Submission by Save Honey Hill**Errors and Omissions in Planning Statement (AW 7.5, REP1-049) and Historic Environment Impact Tables (AW 5.4.13.4, REP1-037)****2 December 2023****Planning Statement**

SHH notes the following errors and omissions in the Planning Statement as updated as REP1-049 on Deadline 1, 20 November 2023.

Drawing Number
 Figure 15.5

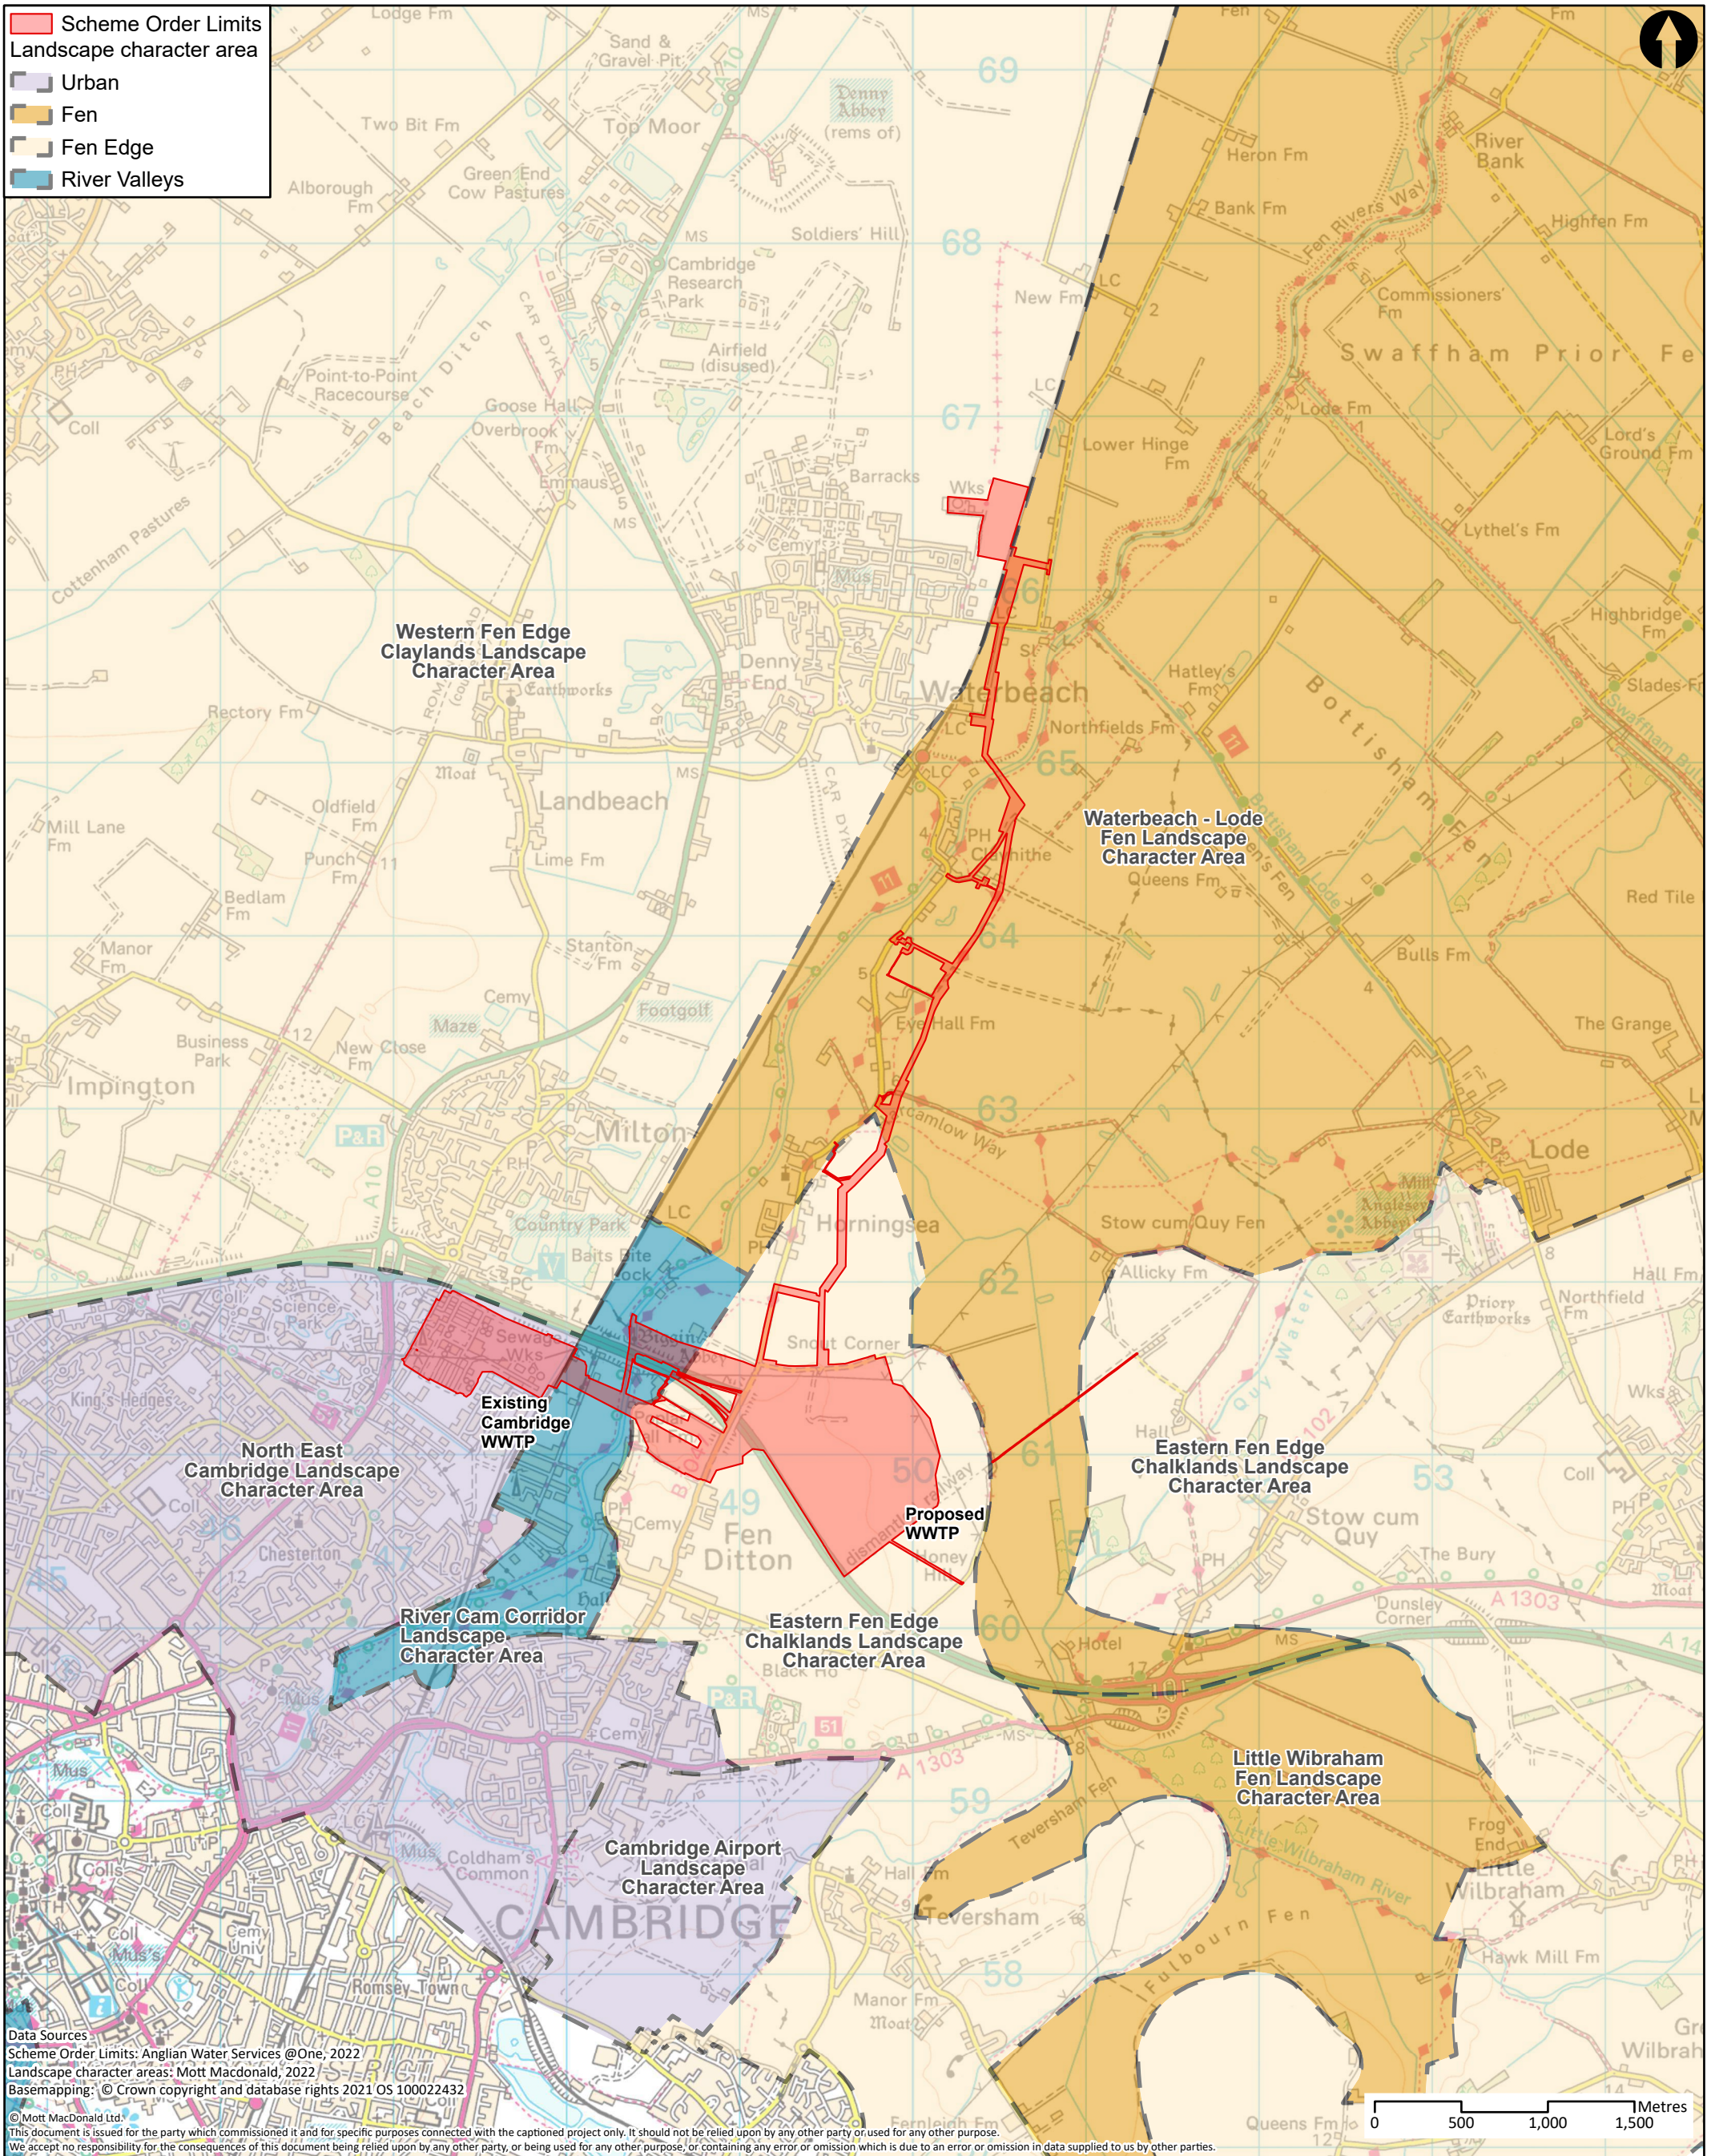
- Eastern Fen Edge Chalklands LCA does not reflect the description of residual effect reported in LVA, AW 5.2.15; AS-034 Table 4.5 including, for example, the remaining exposure of industrial buildings and omits to state the permanent moderate adverse significant residual effect assessed and reported in the Table on the LCA.

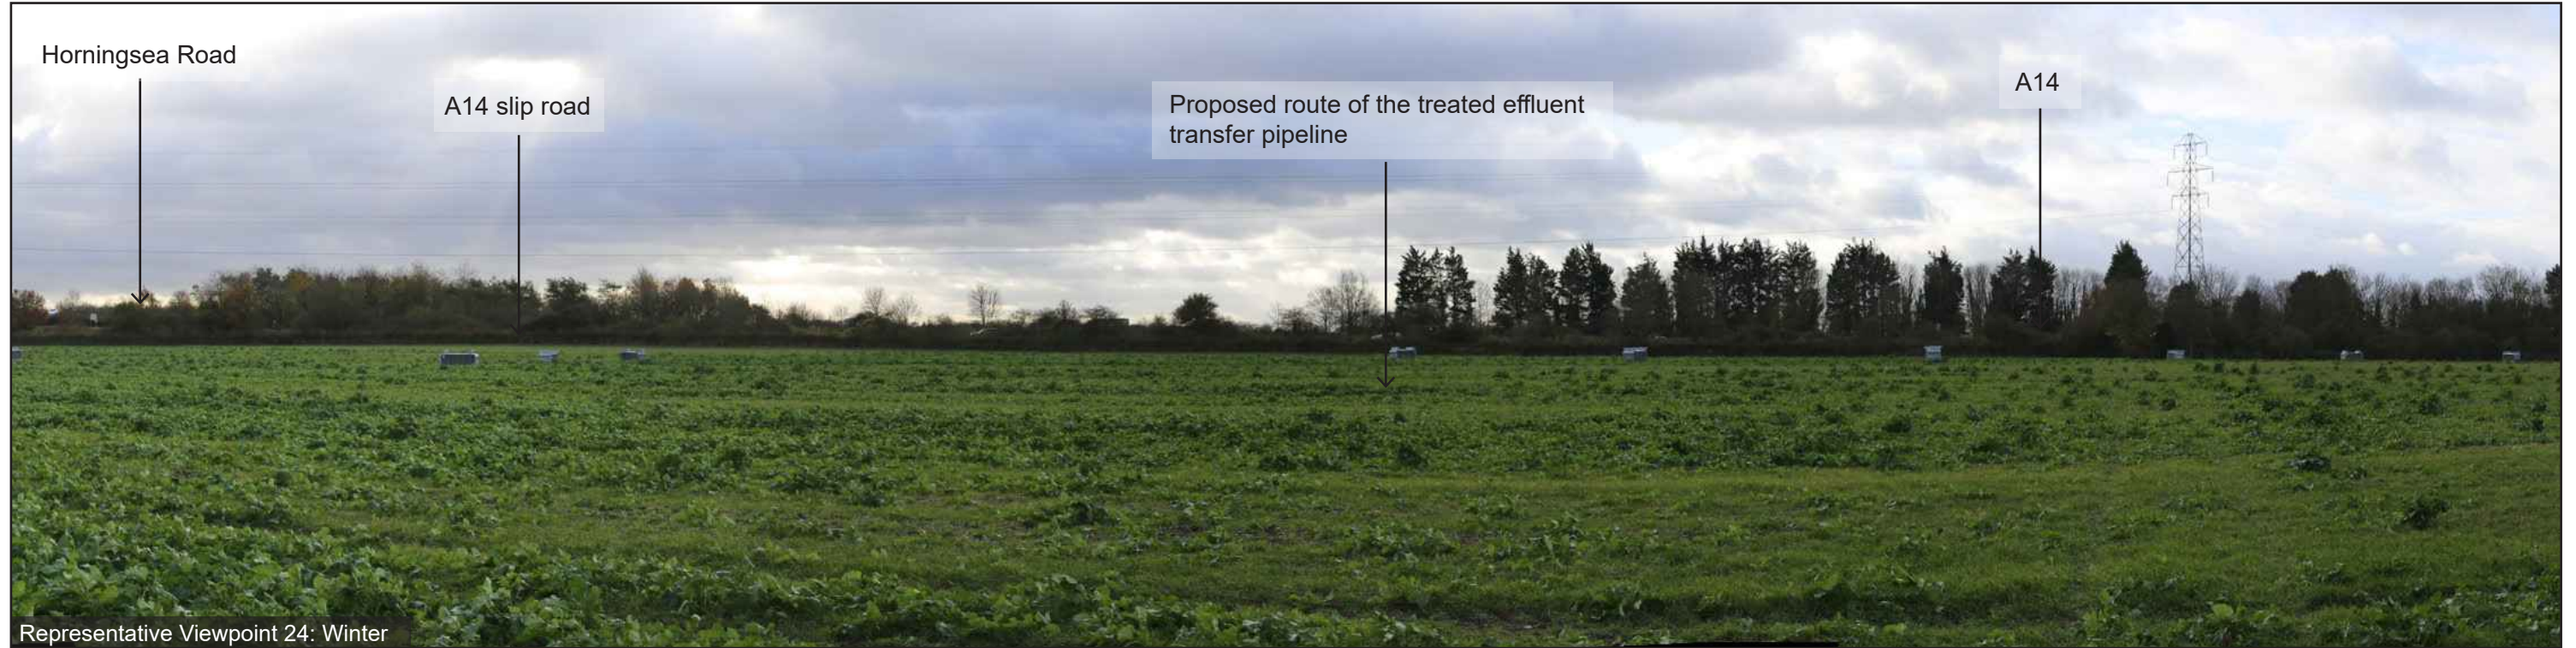
4.10.14 It would seem appropriate here to include the HE outcome on Biggin Abbey II*(HE011). It is noted the LVA assessment on VP 24 is reported but not the HE assessment which identified permanent moderate adverse significant residual effect on Biggin Abbey II*(HE011) at AW HE AW 5.2.13 REP1-23 at para 4.2.55.
